PLANNING CONSULTATION RESPONSE

Application No	2025/0867
Proposal	Erection of outbuilding (retrospective) to be used for golf simulator business.
Address	5 Willow Bank, Barnsley, S75 1BN
Date of Consultation Reply	5 th November 2025
Consultee	Highways DC

Drawing Title.  
**CHANGE OF USE  
GAMES ROOM  
SITE PLAN**

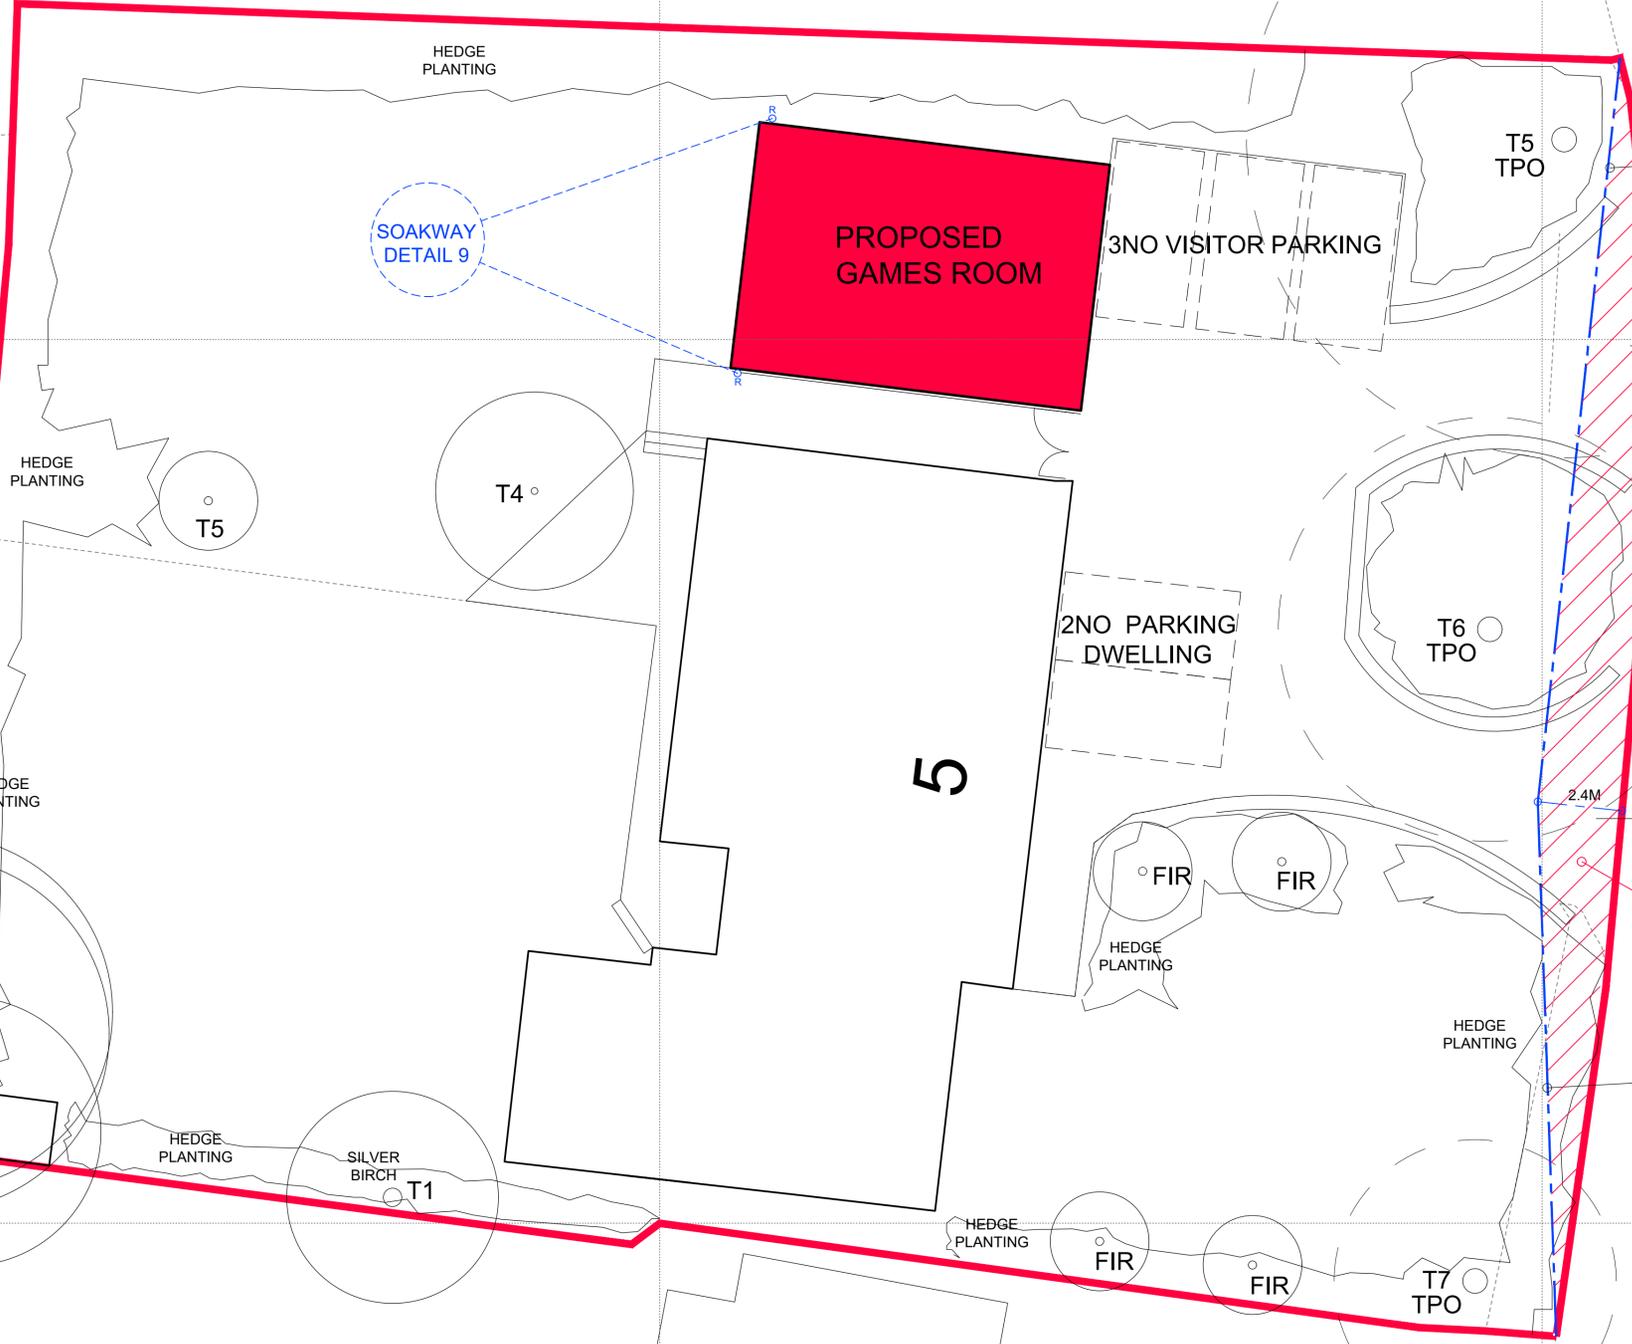
The submitted information states that 8no. parking spaces are to be provided within the site, however, it is unclear where these spaces are located as they are not shown on any plans. A site layout plan should therefore be provided which clearly shows all proposed parking spaces; it should be noted that each space must have minimum dimensions of 2.5m x 5m, if any spaces are located within a garage, this must have minimum internal dimensions of 3m x 6m per space.

The site has two vehicular access points, as such it is stated that the site would operate an 'in and out' system although it is not specified which access point would be the entrance and which would be the exit. Due to the restricted width of Willow Bank and the absence of any footways, it is noted that visibility appears to be somewhat limited from both access points. It should therefore be demonstrated that the proposed intensification of use of the site would not have a detrimental impact upon highway safety and details of any necessary mitigation measures should be provided.
